Our Ref: R/2019/6/F
File No: 2022/622285
Your Ref: SSD 10340 MOD 2

Advice on Modification - Fort Street Public School Redevelopment - SSD 10340 Mod 2

Lift shaft and Stair Lobby raised  
(610 and 310mm respectively)

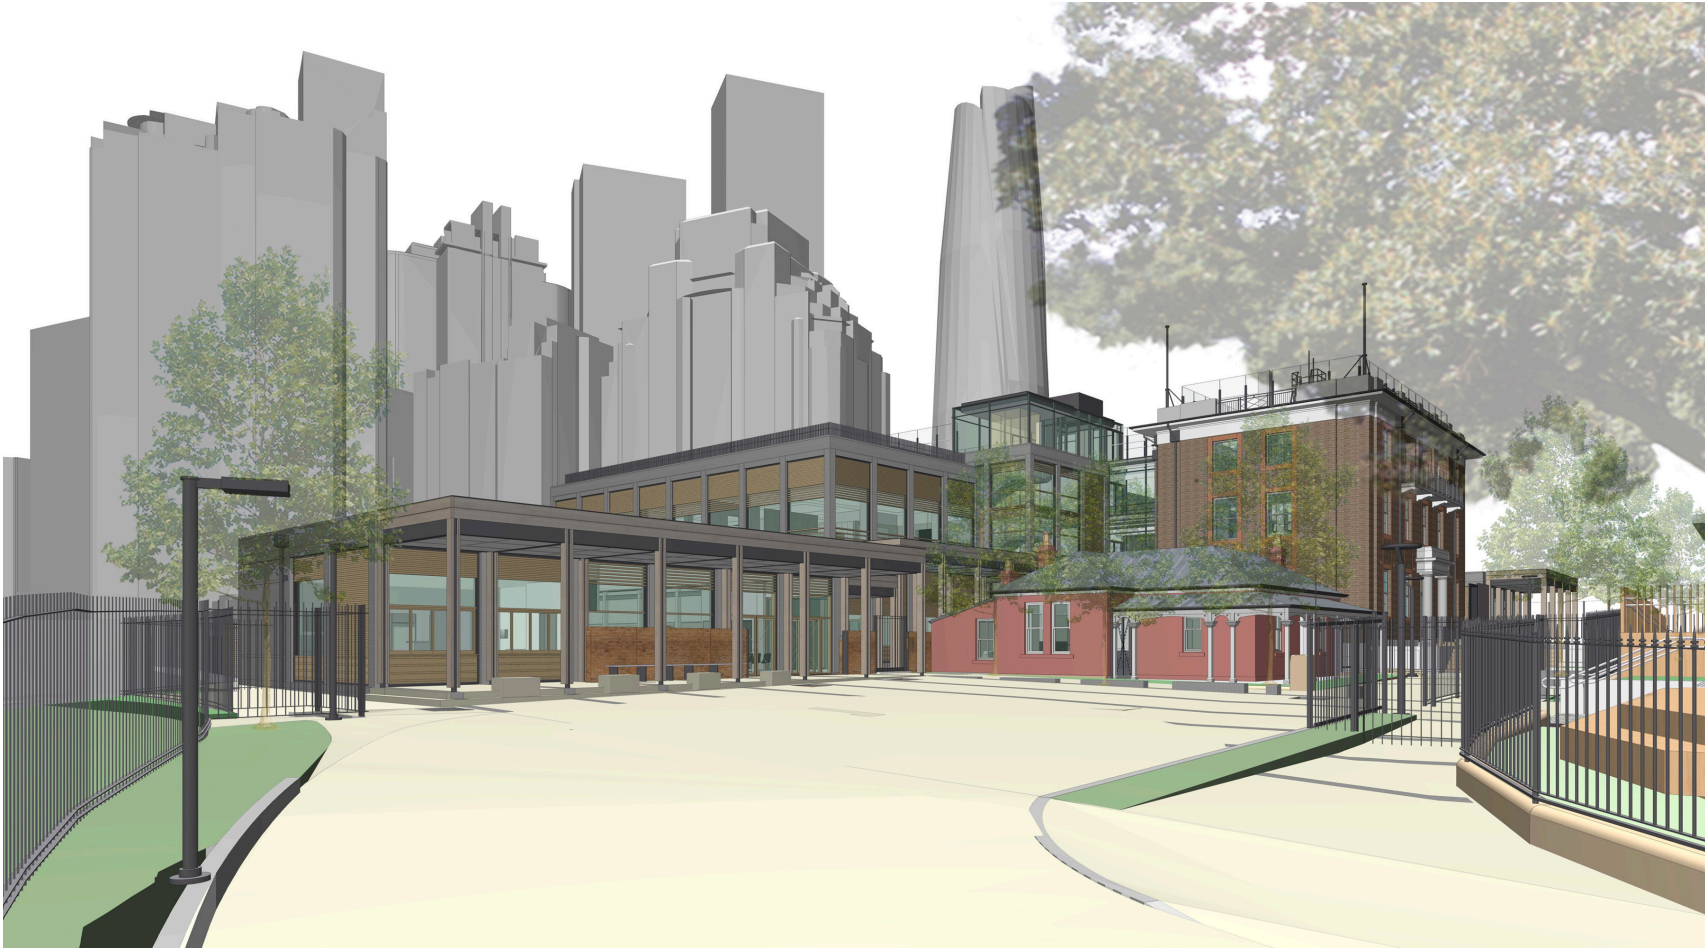
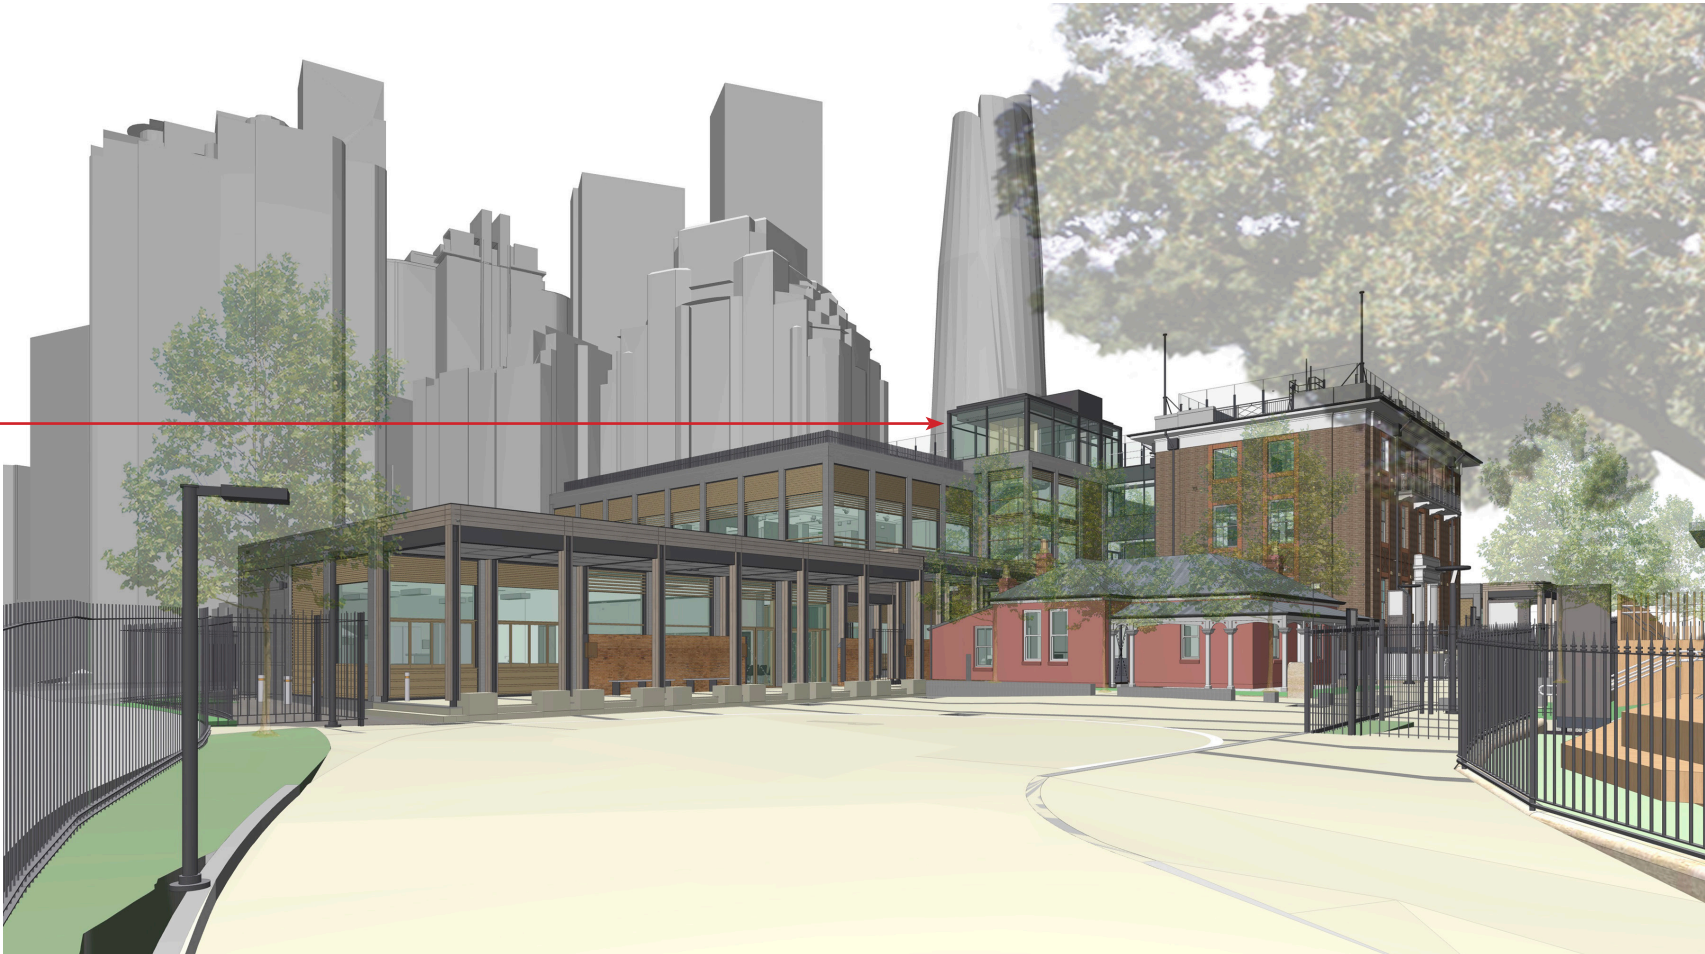
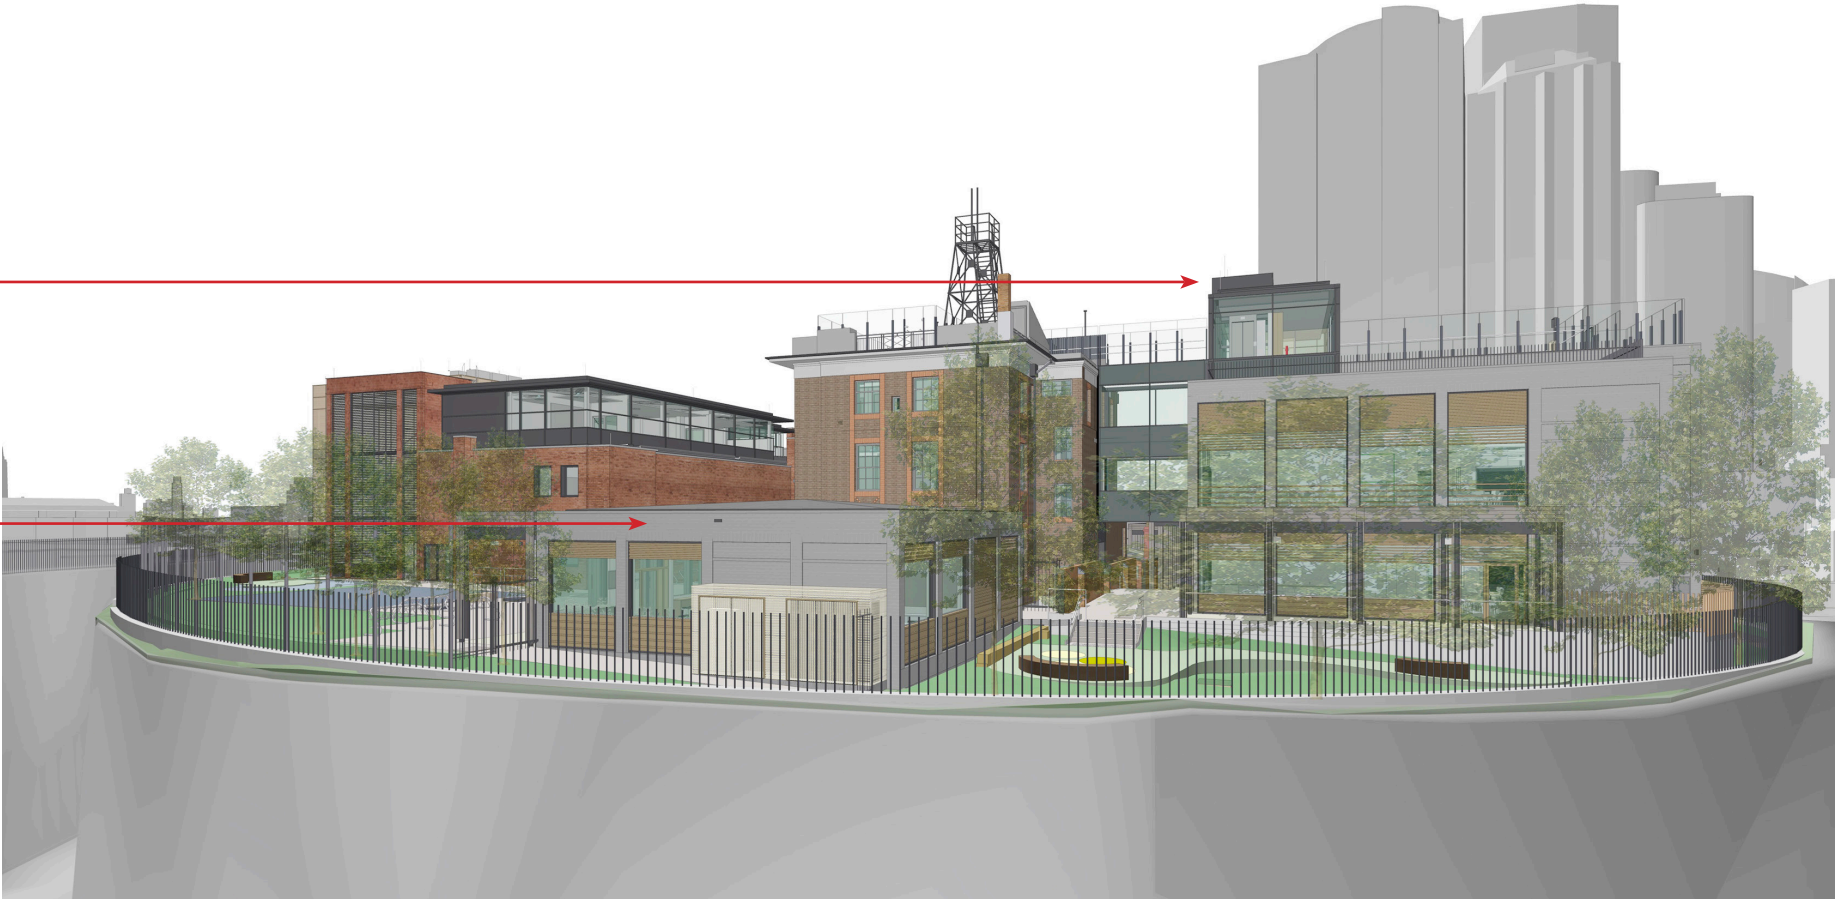
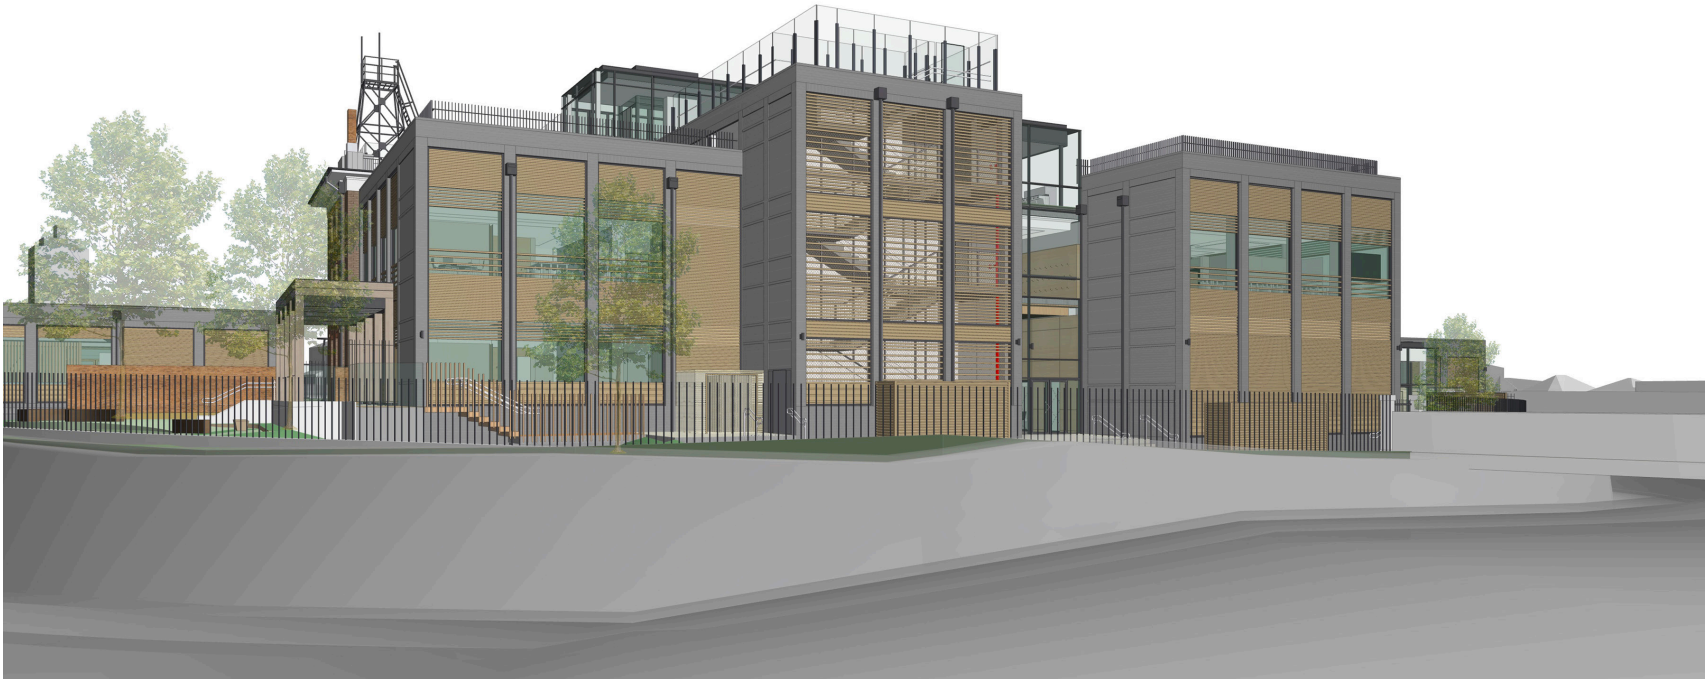
The City has previously raised concern about increased bulk to Building J proposed under Mod 1. Residents of Millers Point and the National Trust have also previously objected to the increased bulk and visual impacts from the increased height of Building J.

While we note that the height increase to Building J proposed under Mod 2 is a result of lift requirements and technical considerations, the City recommends that the height be minimised as much as possible to reduce any further bulk and scale impacts.
